From: Charlotte Burrows on behalf of Planning.Responses
Sent: 26 October 2017 16:37
To: Planning Scanning
Subject: FW: BE/102/17/PL - Saltbox Bognor Regis-Acoustic Barrier Height.

From: Martin Court [REDACTED]
Subject: Saltbox Bognor Regis-Acoustic Barrier Height.
Date: 24 October 2017 at 15:48:43 BST
To: Arfon Hughes [REDACTED] Nia Russell [REDACTED]

2A: With Acoustic Barrier L_{Aeq}

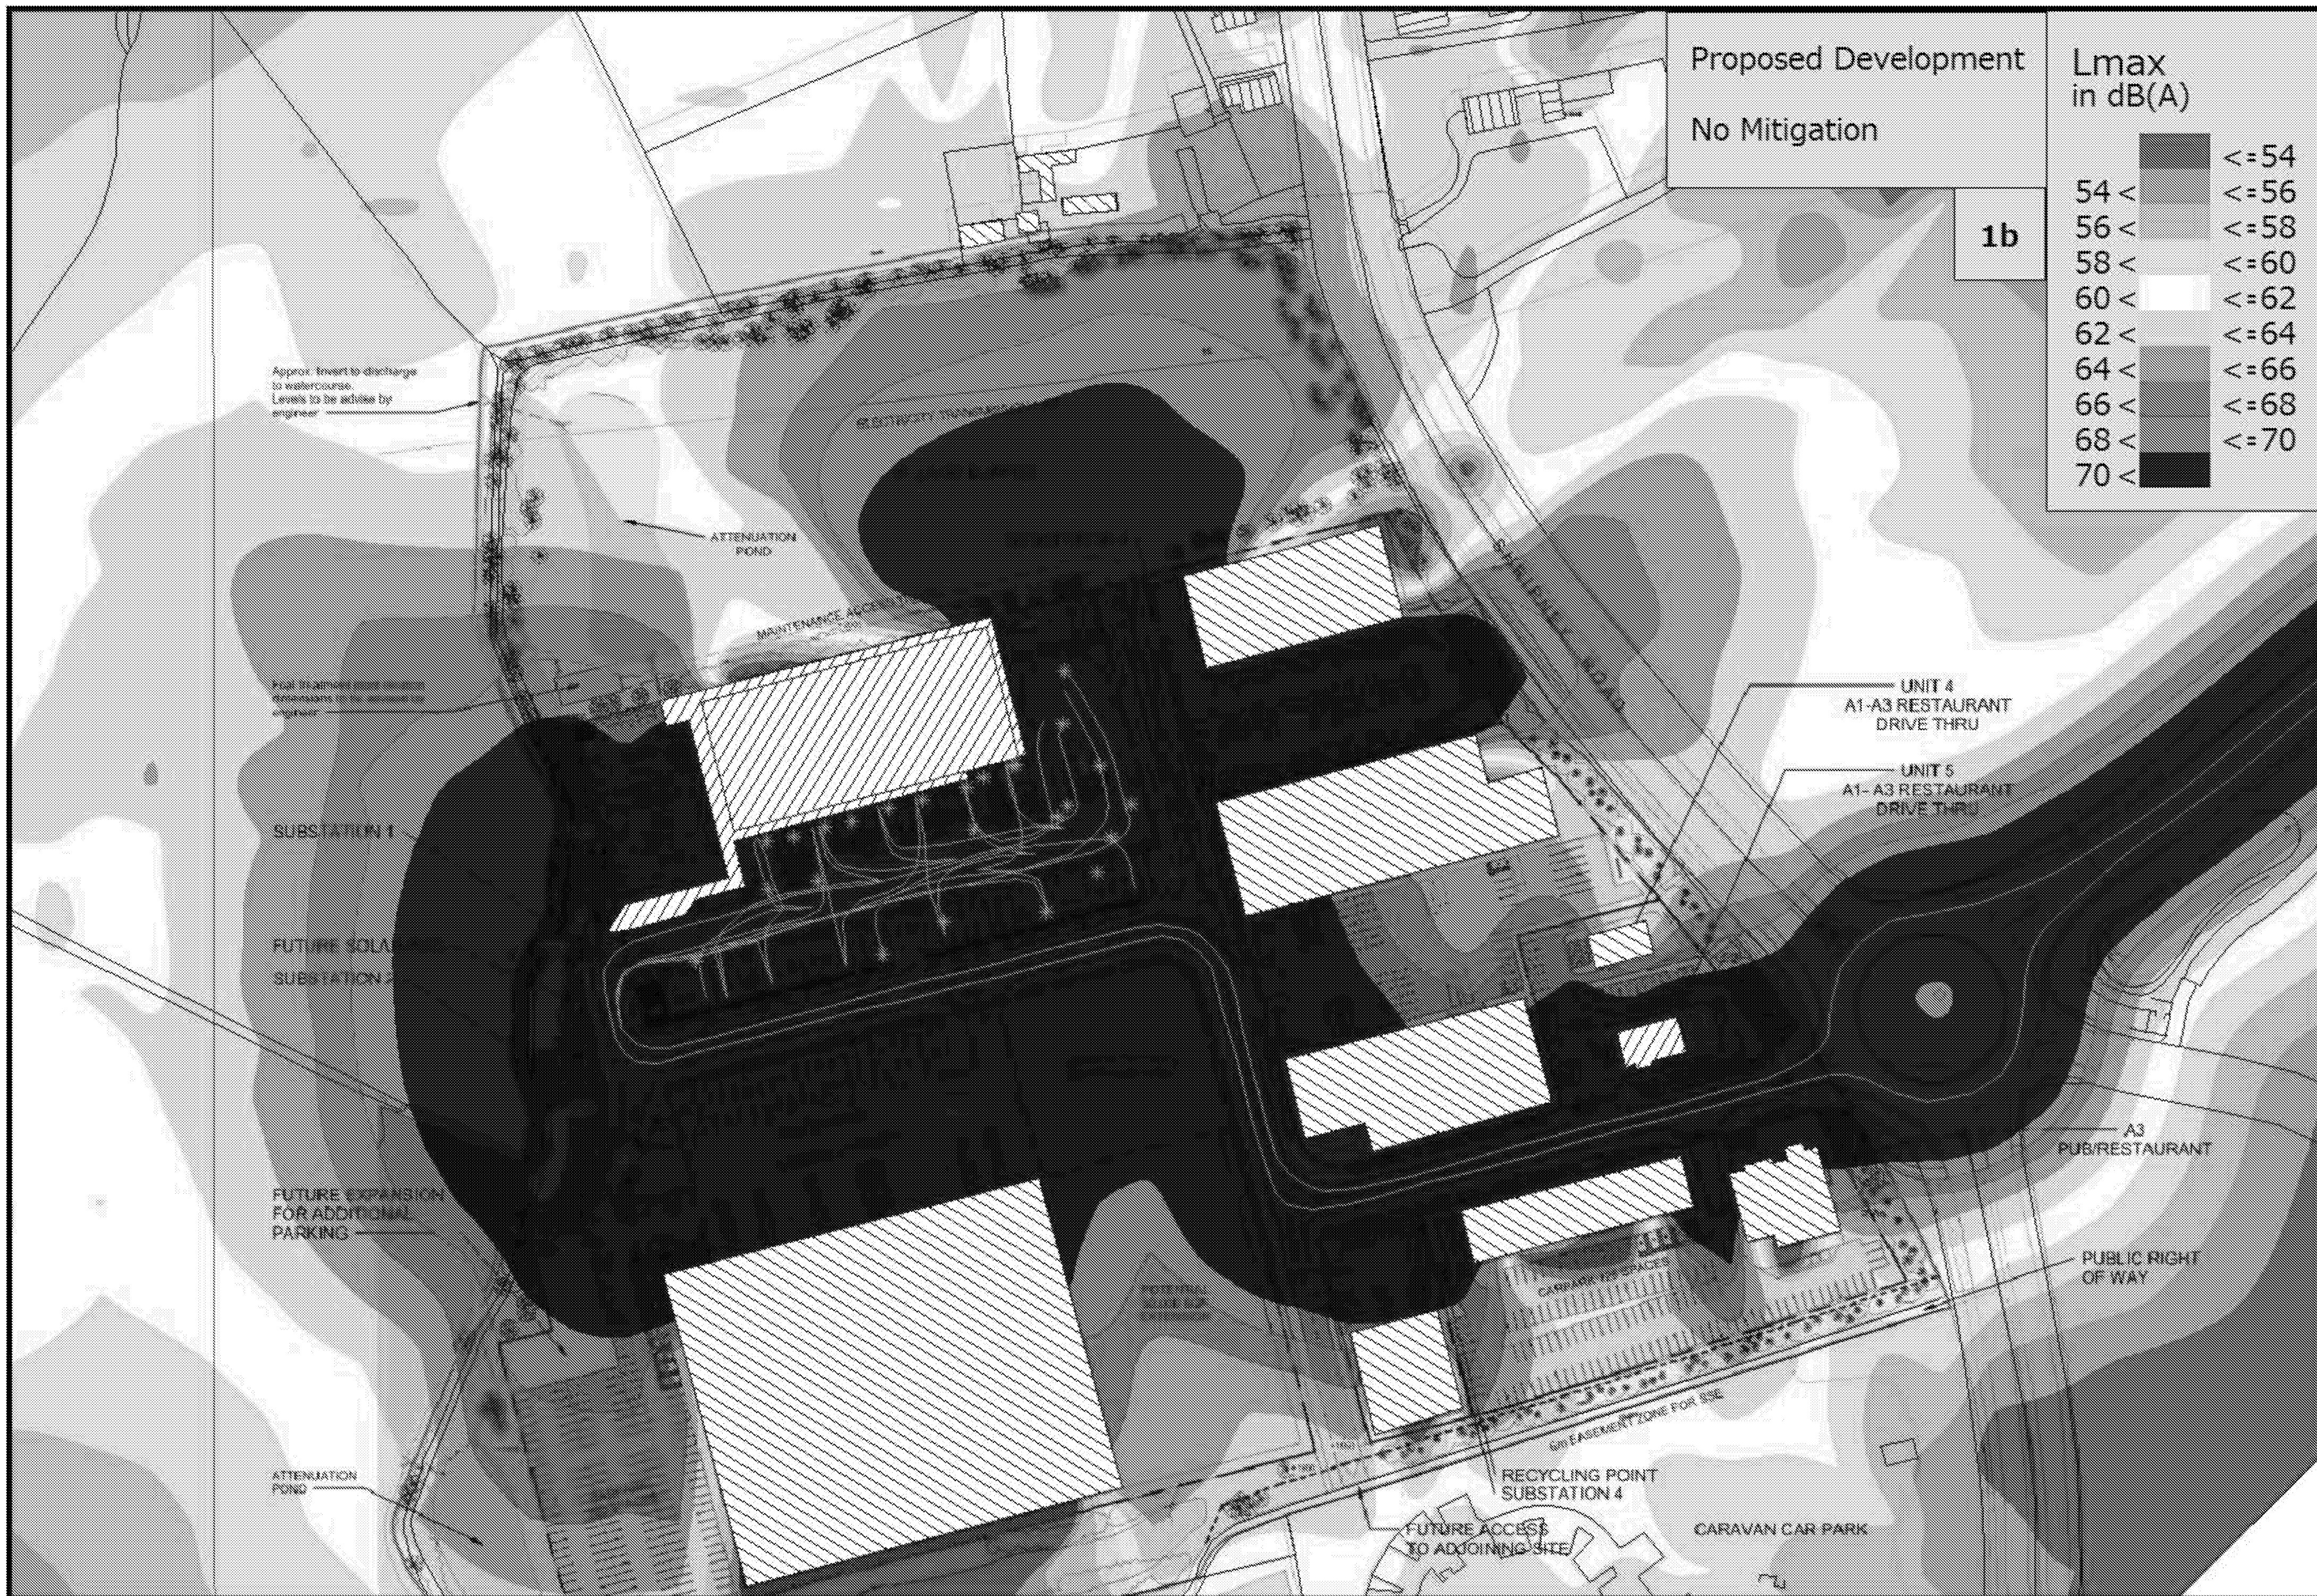
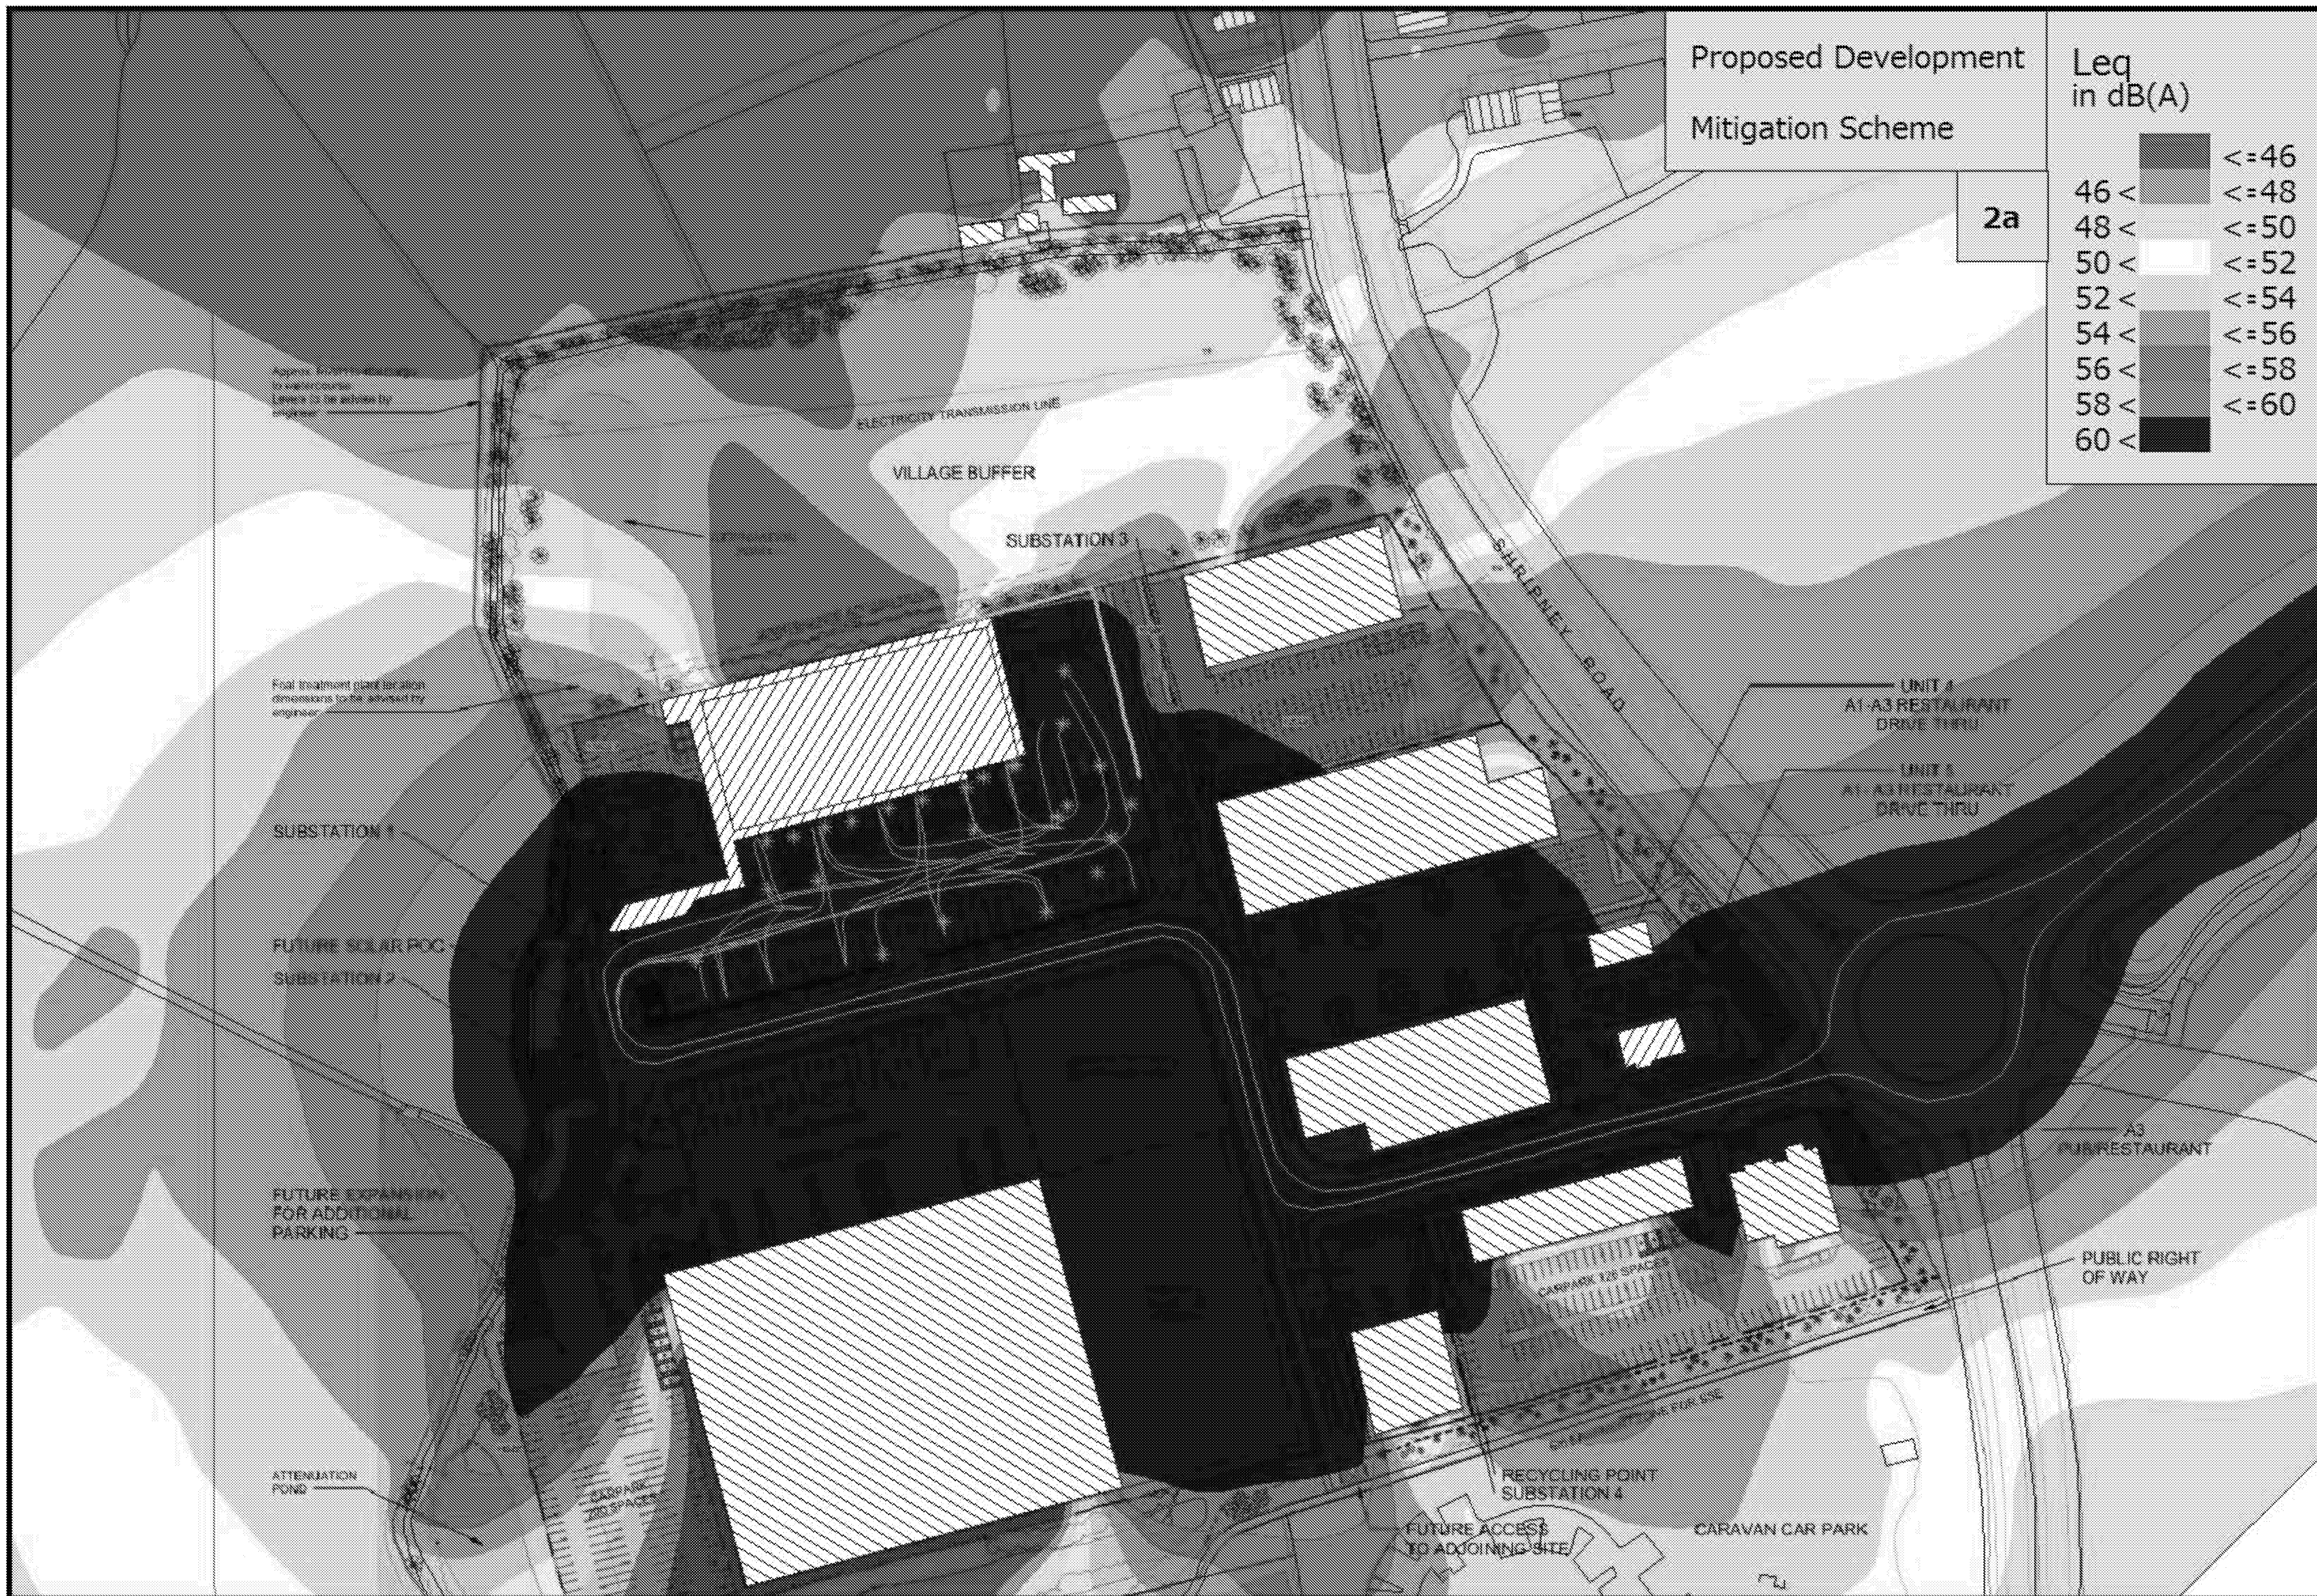
In answer to your query in relation to the height of the acoustic fencing, please see the response below from the acoustic engineers. I trust that this answers your query in terms of the proposed height of the fence, however please let me know if you require any further information.

Further to our conversation, we have rerun the SoundPLAN models to show the acoustic performance for 3m height and 4m height acoustic barriers to the north of the site, further to our earlier report. With a 4m high barrier, the L_{Amax} parameter used for night time noise events and potential sleep disturbance enables levels of 45dB as L_{Amax} as an internal level in the nearest residential property bedroom to be met with windows open. This equates to 60dB L_{Amax} outdoors. These figures are referenced within WHO Guidelines and BS8233:2014 for appropriate and desirable internal levels.

If the barrier is reduced to 3m then the level raises to between 62-64 dB L_{Amax} outside which would mean that internal levels would be compromised above the criteria referred to in the WHO guidelines and BS8233:2014.
